ISH3 Thurs 8 Dec_Part2

Created on: 2022-12-08 14:05:13

Outline landscape mitigation strategy

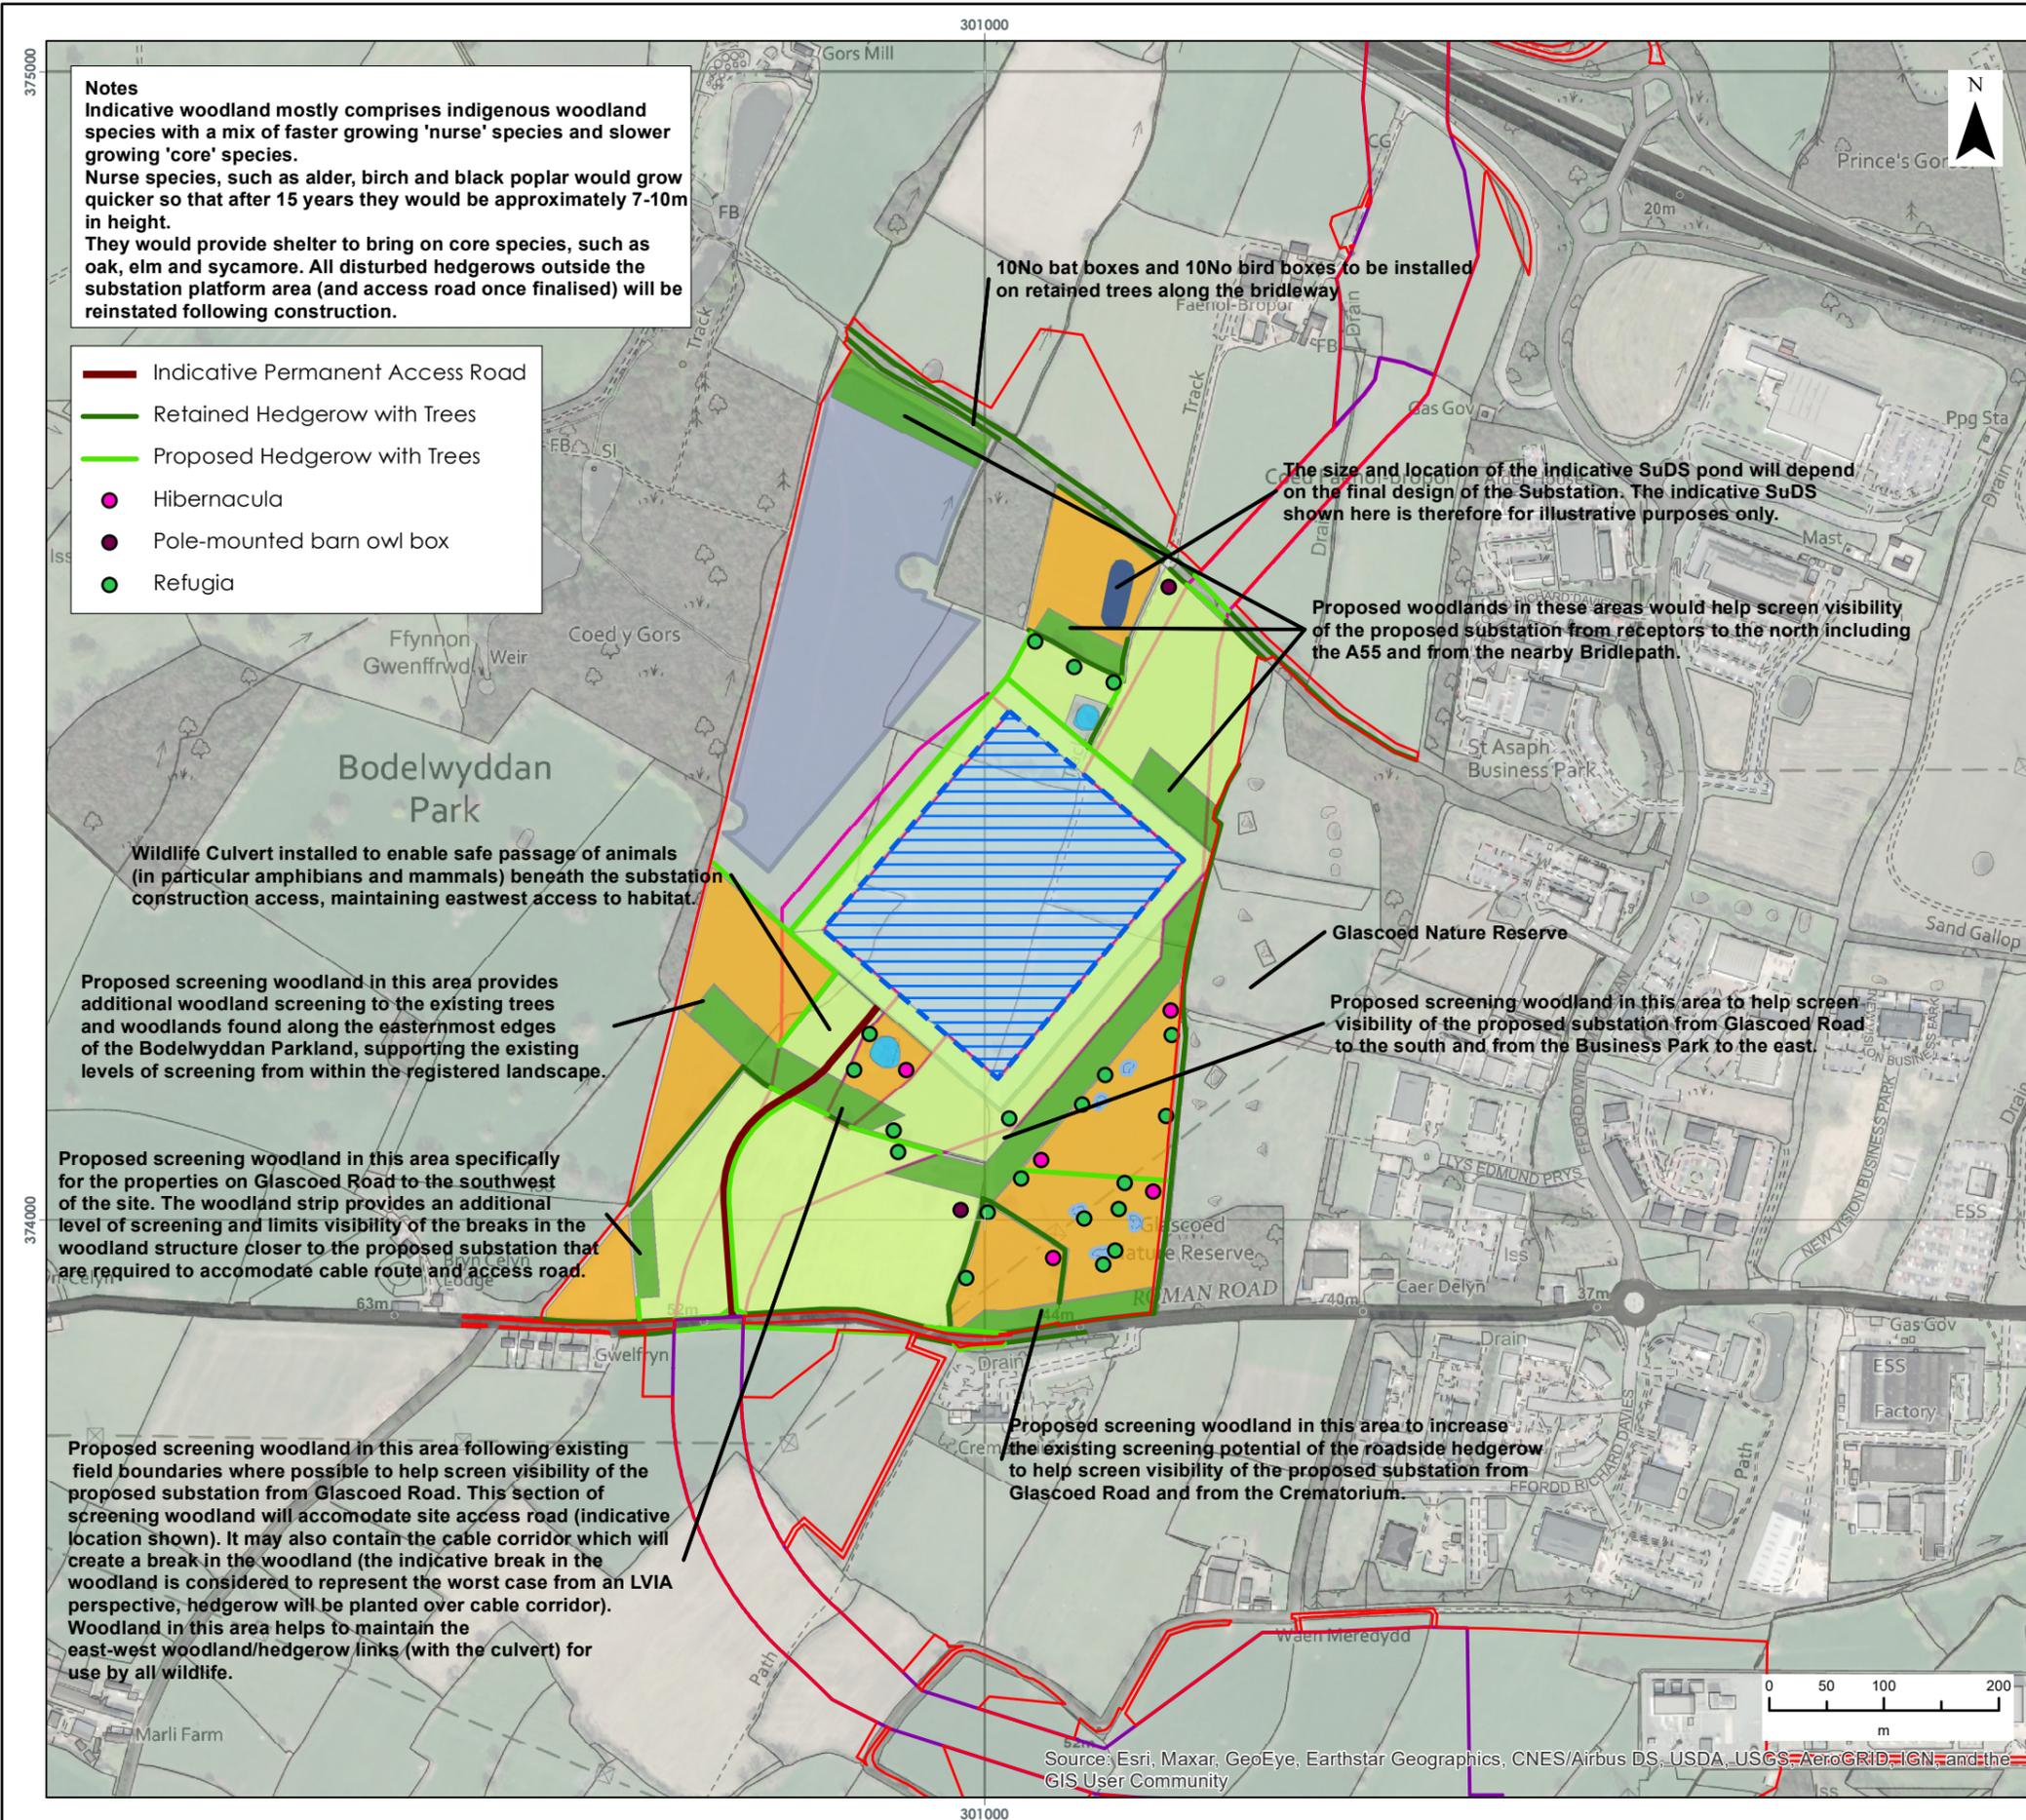
Thank you very much. I think it'd be useful to have figure two of the outline landscape technology management plan on the screen, if possible, please.

The references. Wrap to Dash 010.

So whilst it's coming on the screen, my question was figure two shows, landscaping and sort of habitat creation around the substation site. Would this plan be the same for both the gas and the gas options? Because this does this just show the air option?

Linda Thompson for the applicant. I think it is a very outline stage in terms of it shows some of the principles. But I think when you we come on to having detailed design that that would evolve. So I think I can describe what the principles of the arrangement I am and why we've come up with this. The woodland areas within the locations we have, but through detailed design of a gas option, where to come forward with some of those locations would inevitably change.

Okay? And that's because the effects within the blue area would be smaller.

Correct? Yes.

So that would be potential for, say, if the gas option was used, a greater sort of buffer zone between the nature reserve and the substation site.
